**Planning Application No: S6/2008/2412/FP**

**Proposal: Two Storey Rear Extension, First Floor Rear Bay Window & New Garage**

**Location: 65 Pine Grove, Brookmans Park, Hatfield, Herts. AL9 7BL**

First Floor Plan

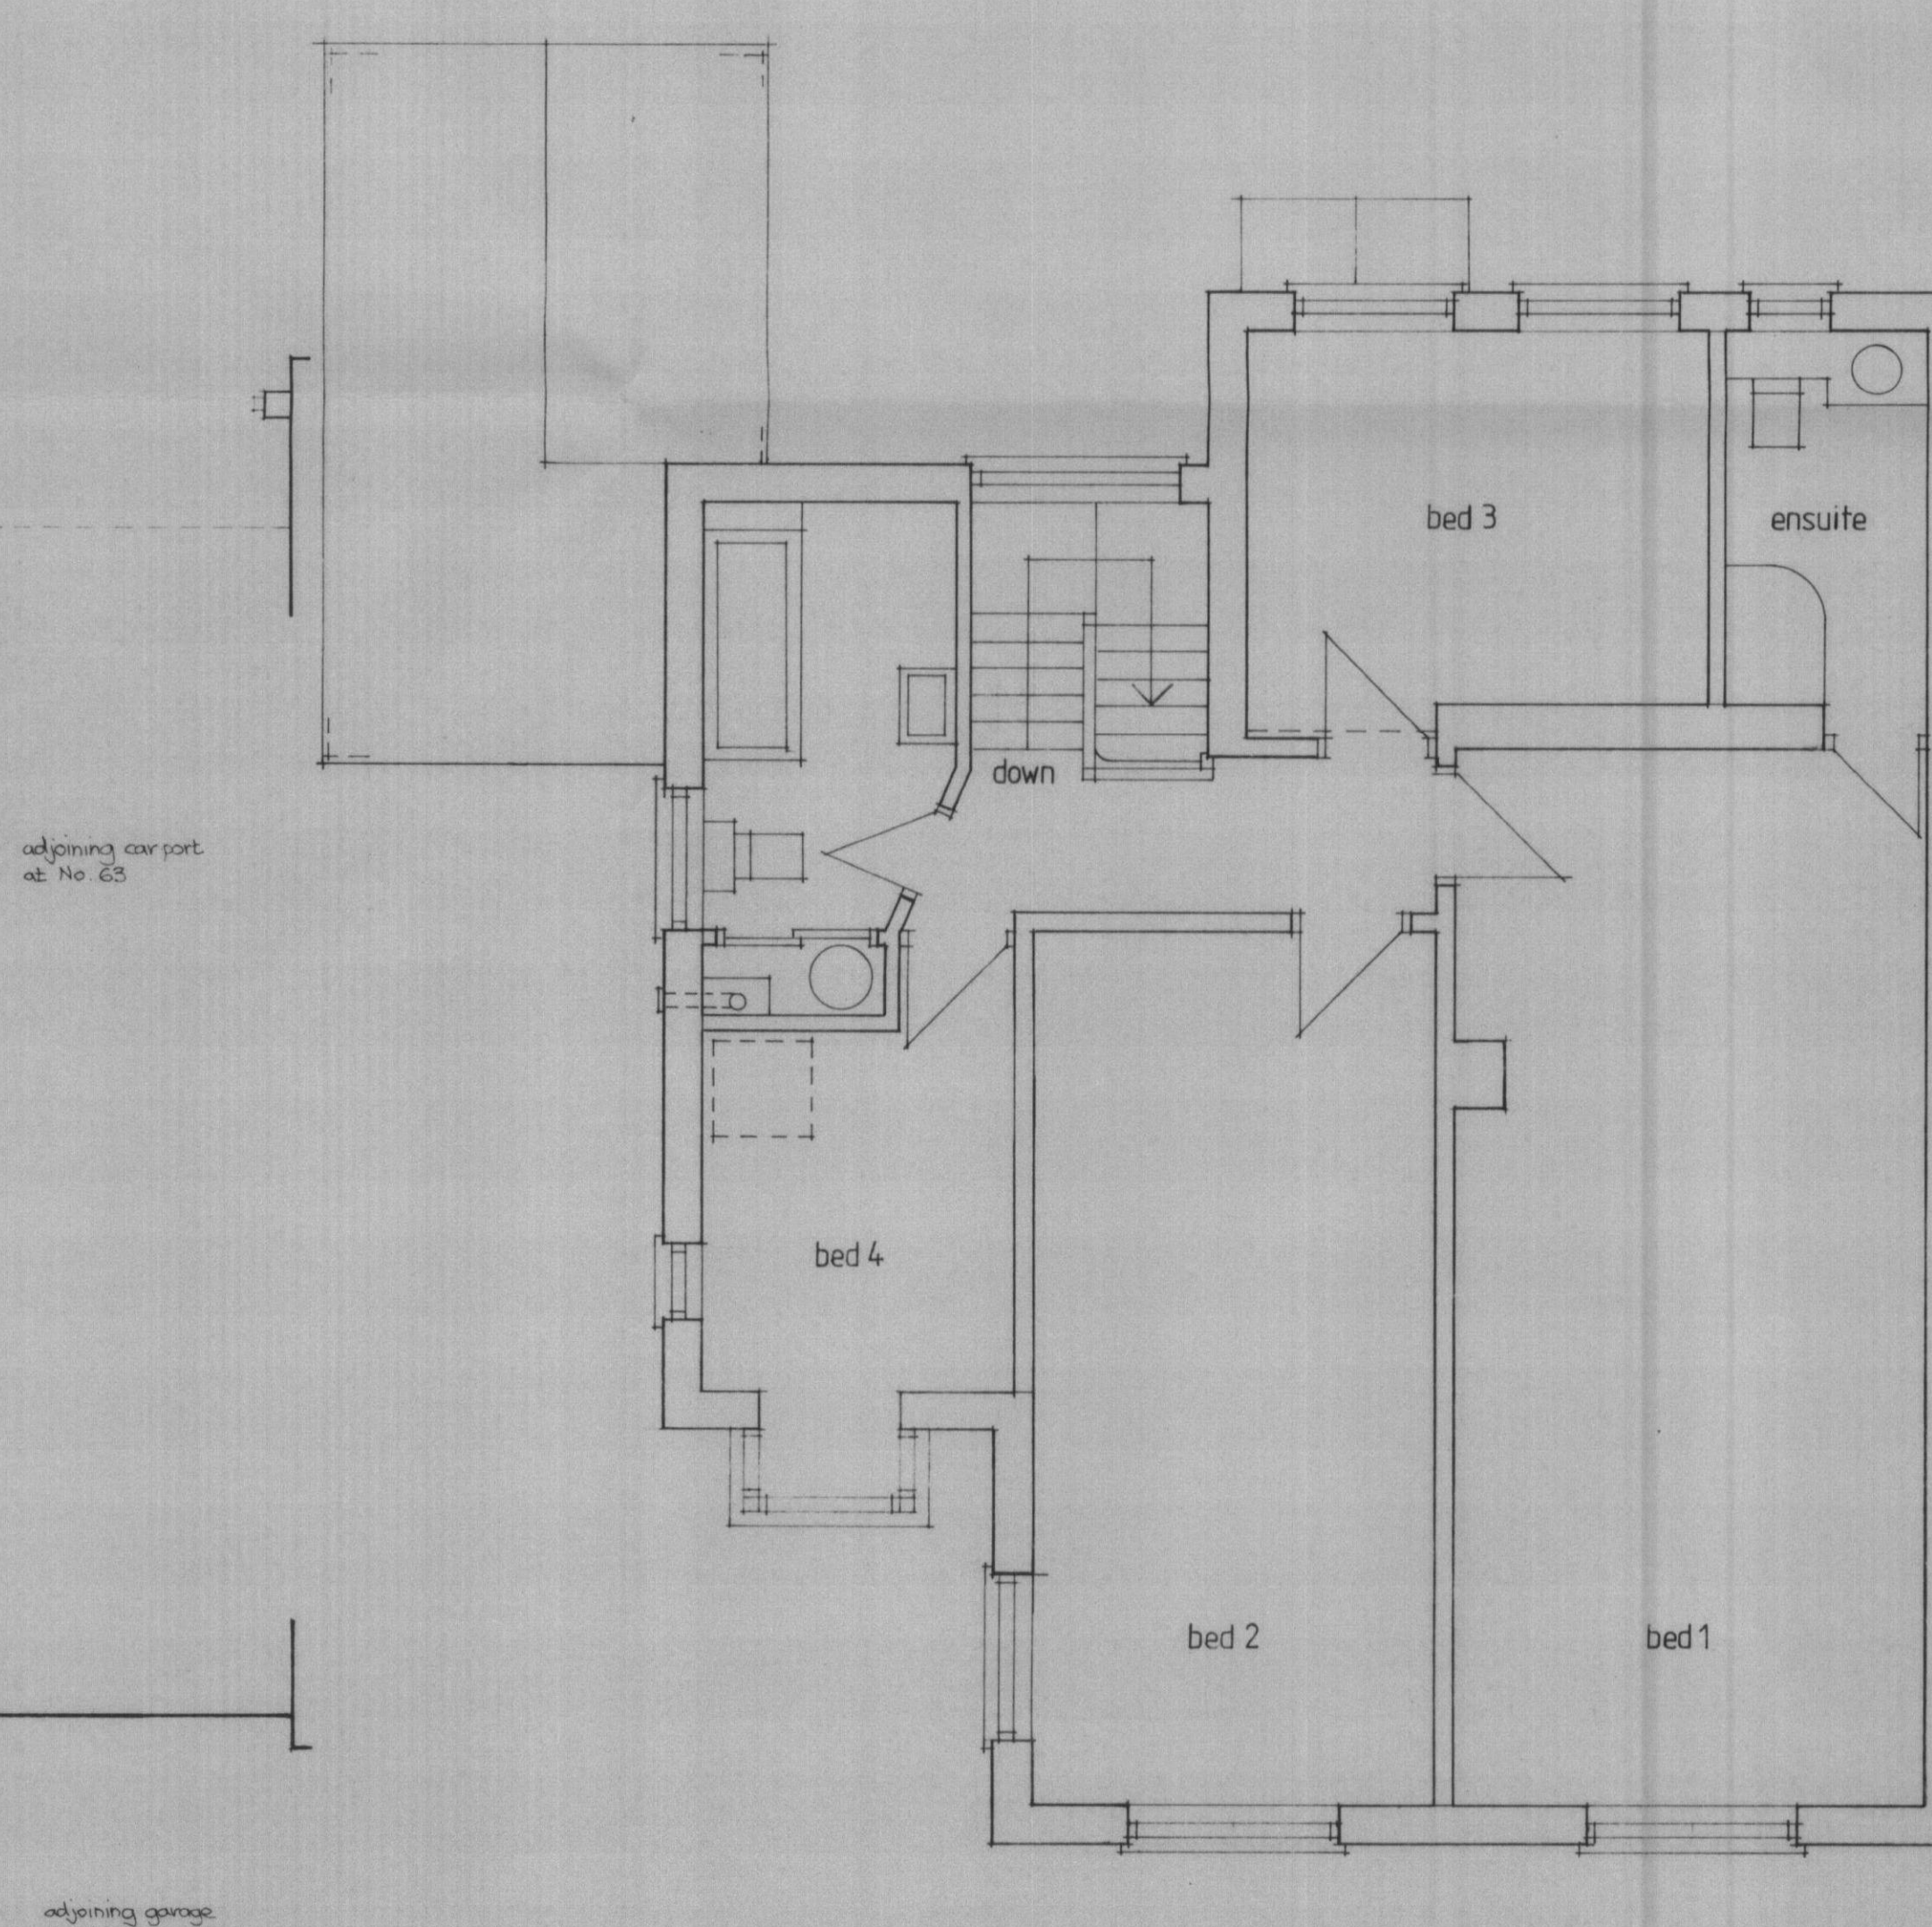
Thank you for giving my Client the opportunity of amending the drawings in order to obtain planning permission. I enclose 2 copies of drawing no. 0801/03C showing the garage reduced in size at the front of the house, all to your requirements.
